April 16, 2004

RE: Parkside Affordable Housing/Neighborhood Center (048 B011)

Mike Nugent
Manager of Inspection Services

HVAC1.3

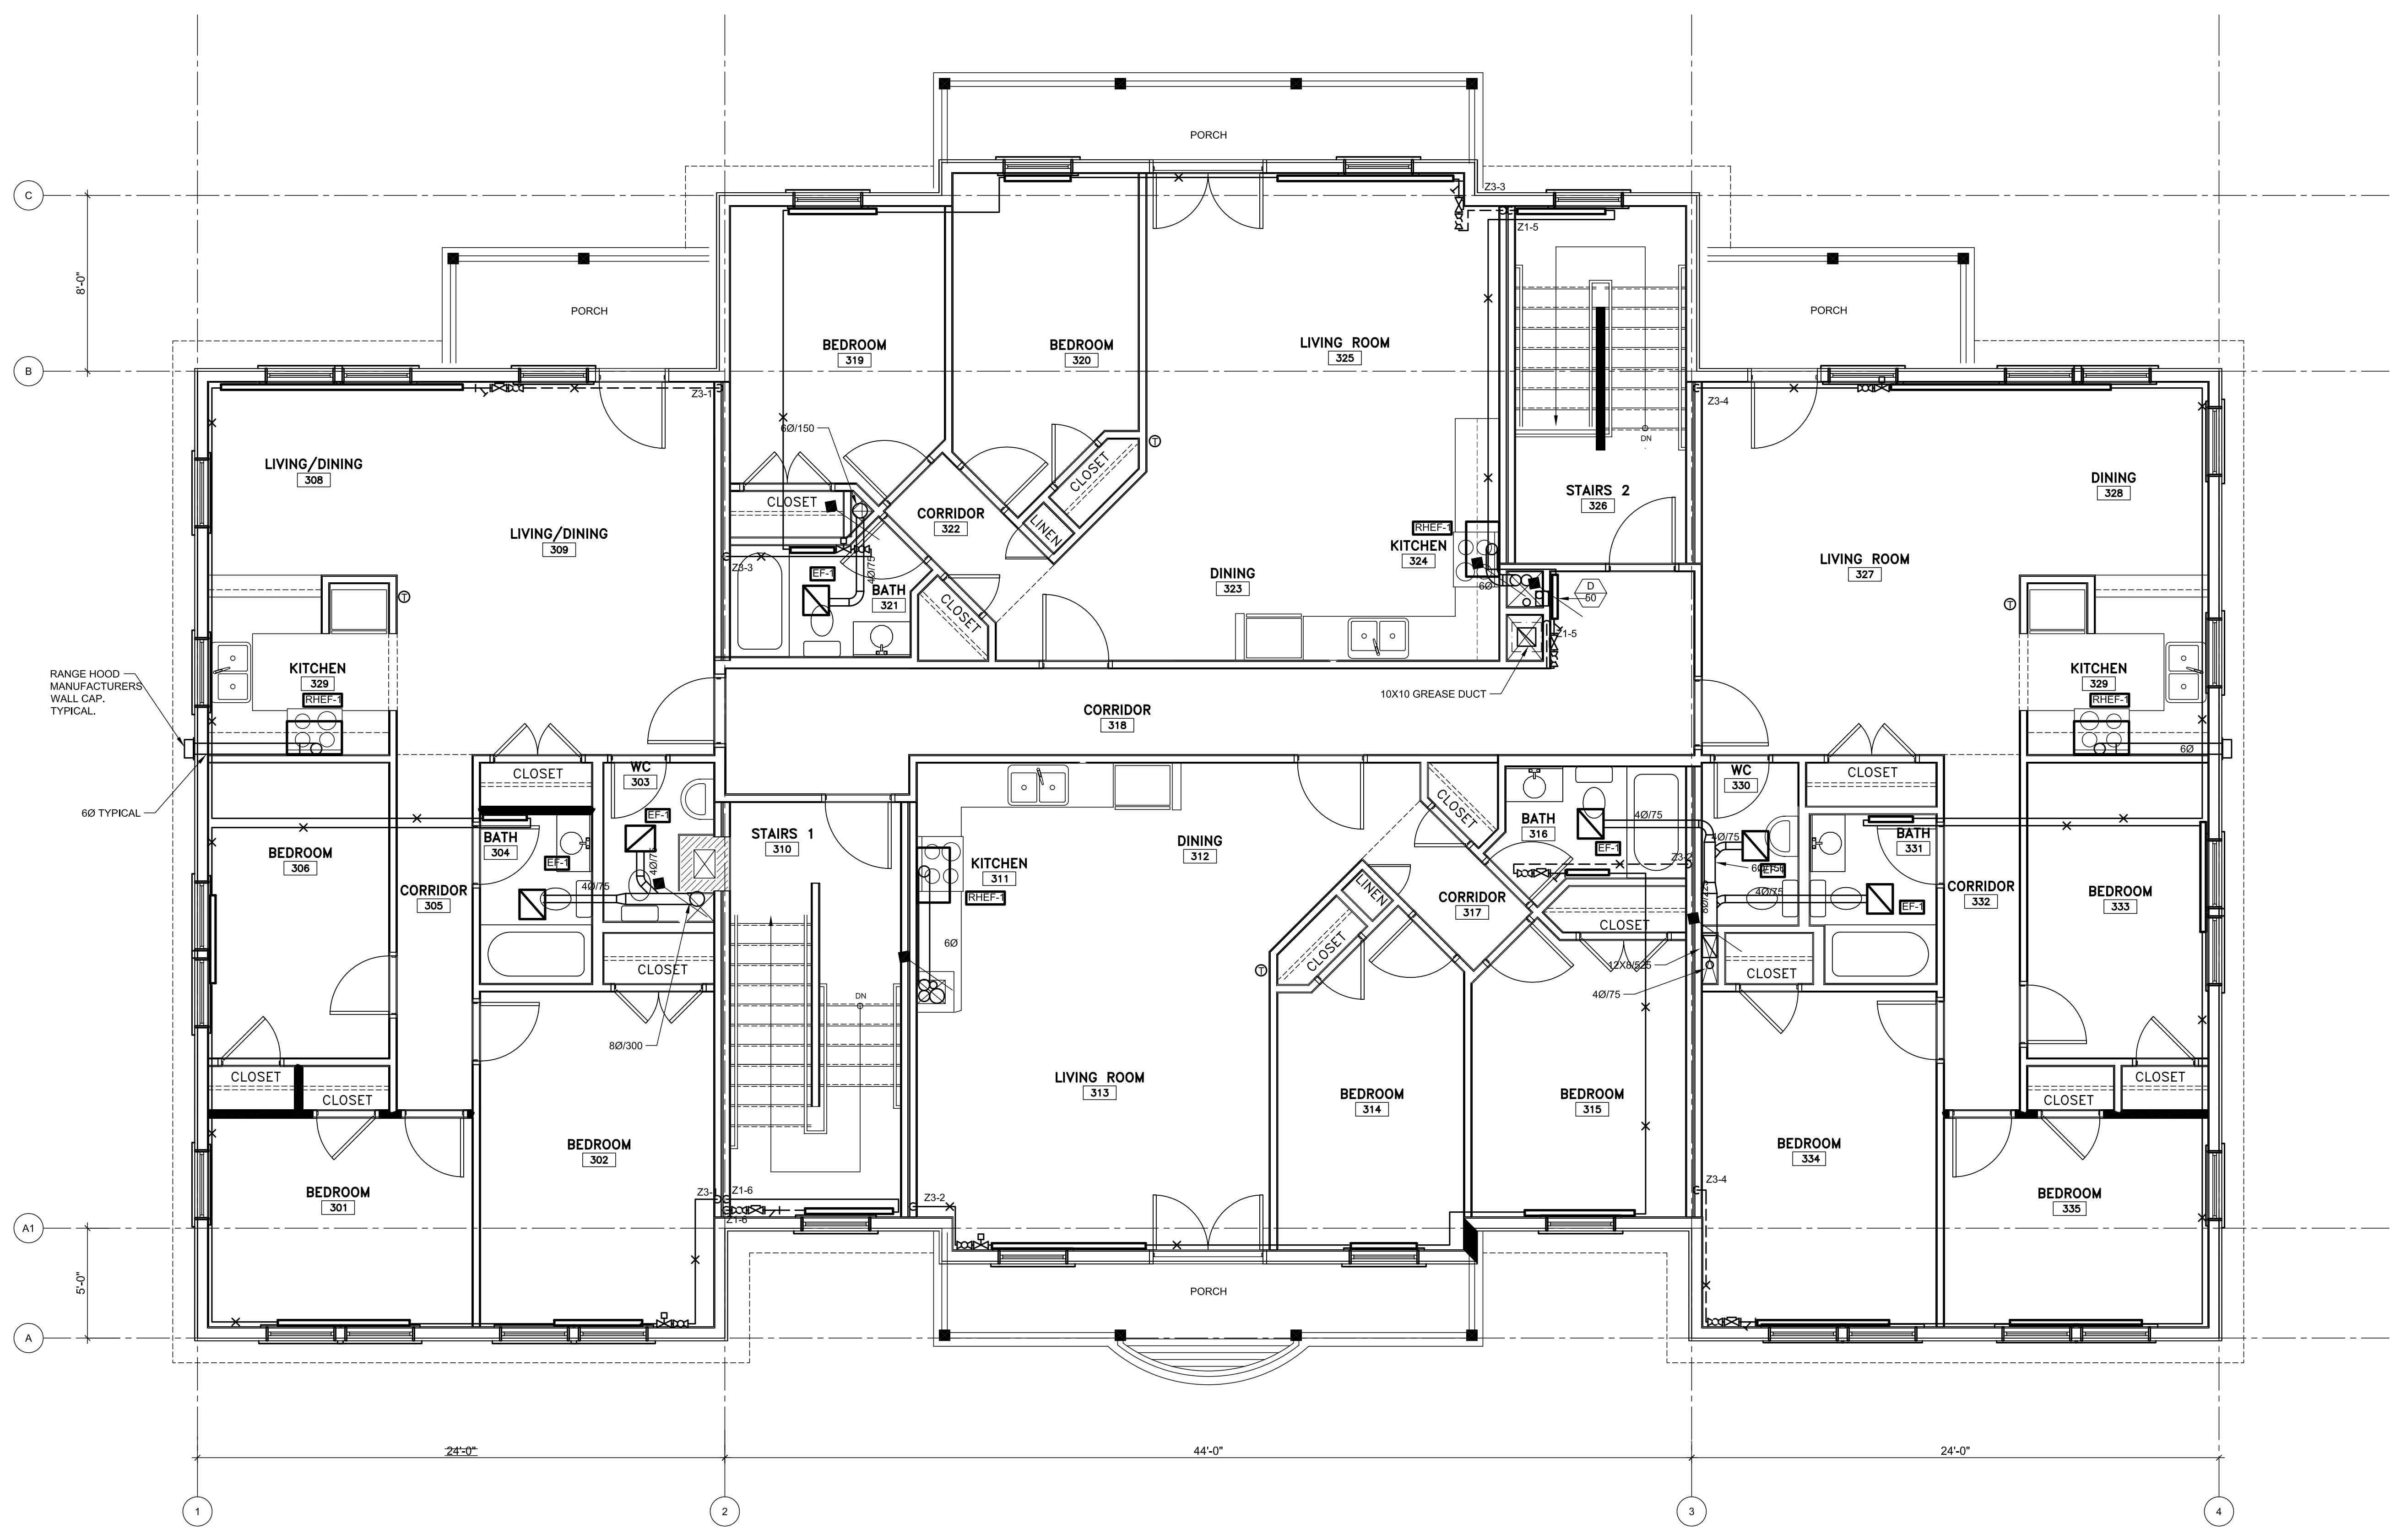
- 1) Fire Dampers for Building "A"; because we are increasing the fire suppression to a full NFPA 13 system we can eliminate fire dampers for HVAC ducts that penetrate rated wall assemblies pursuant to Section 714.1.5.1.1.3. To allow this, the Shaft rating shown on the plan will be downgraded to a 1-hour rating based on your assertion that all shafts in this project connect less than four stories pursuant to Section 710.3. All Duct penetrations of rated floor separation assemblies shall be protected with appropriate fire dampers and will the penetration at the "top" of the shaft.

HVAC1.0

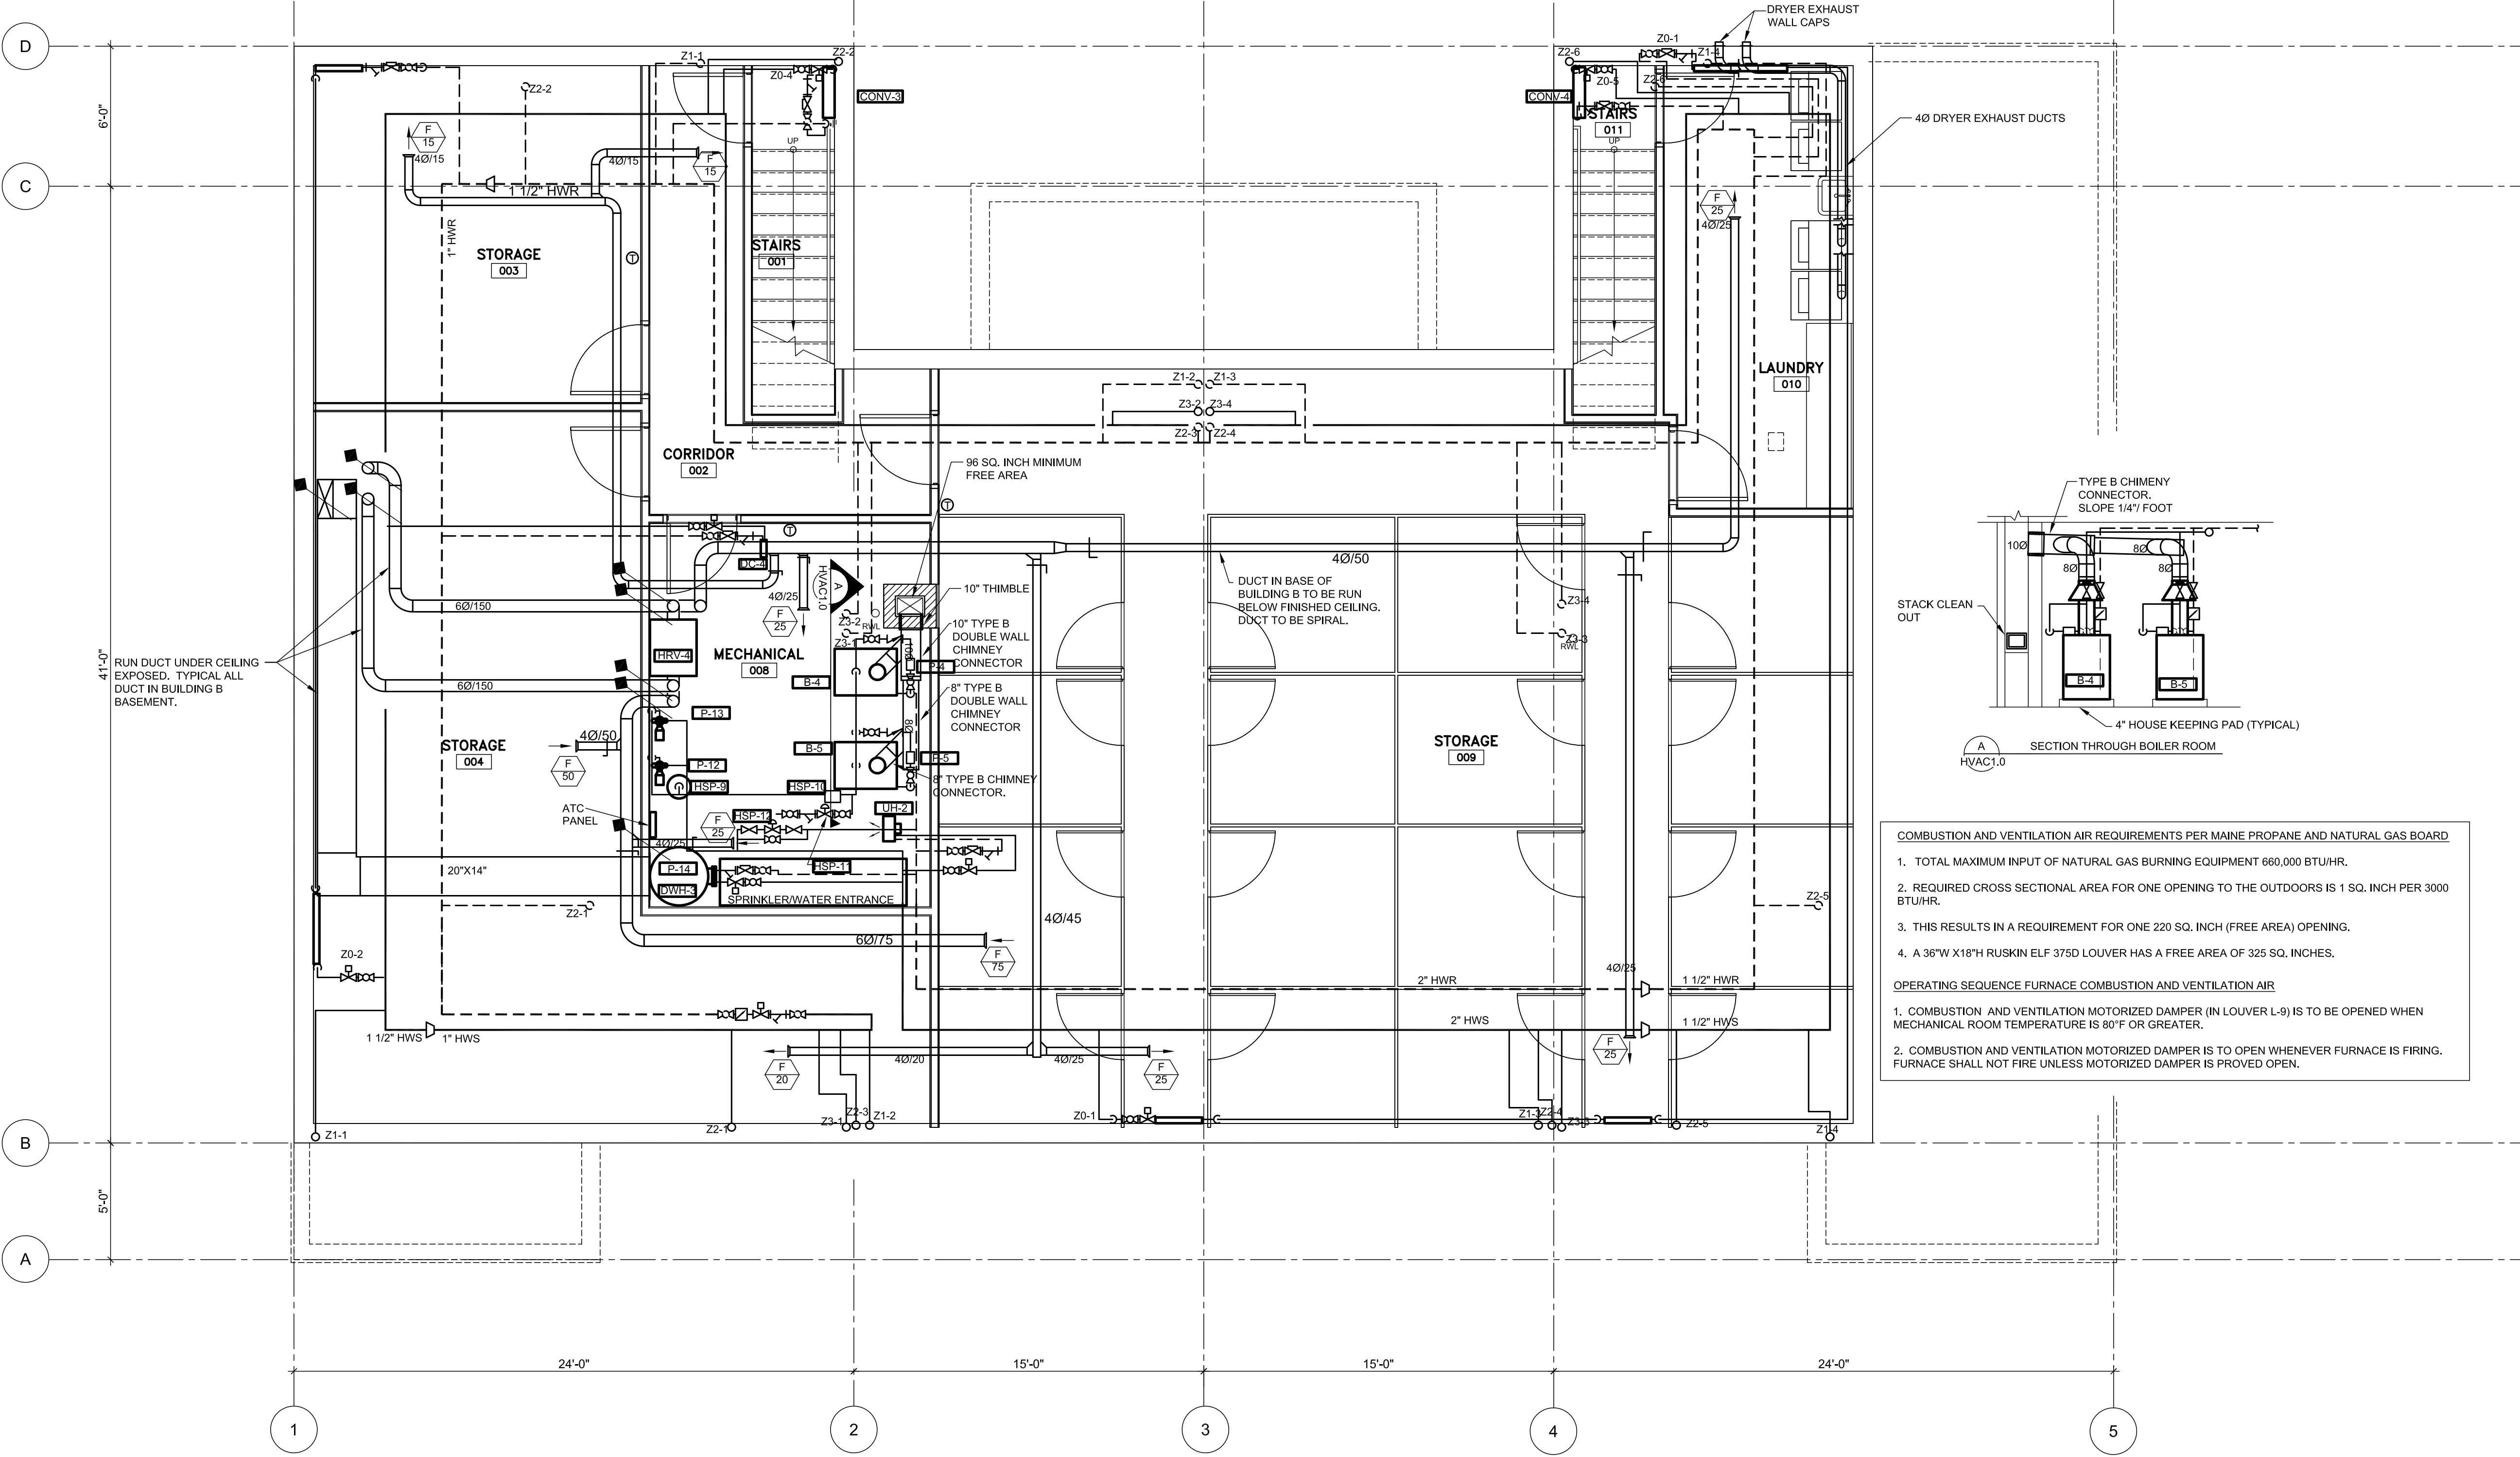
- 2) Fire Dampers for Building "B"; because we are using an NFPA 13R suppression system, all duct penetrations of rated floor/ceiling, wall and shafts must have fire dampers. This includes double dampers where vent penetrate the ceiling and then the shaft. Both require dampers as well as the top and bottom of the shaft if there are penetrations.
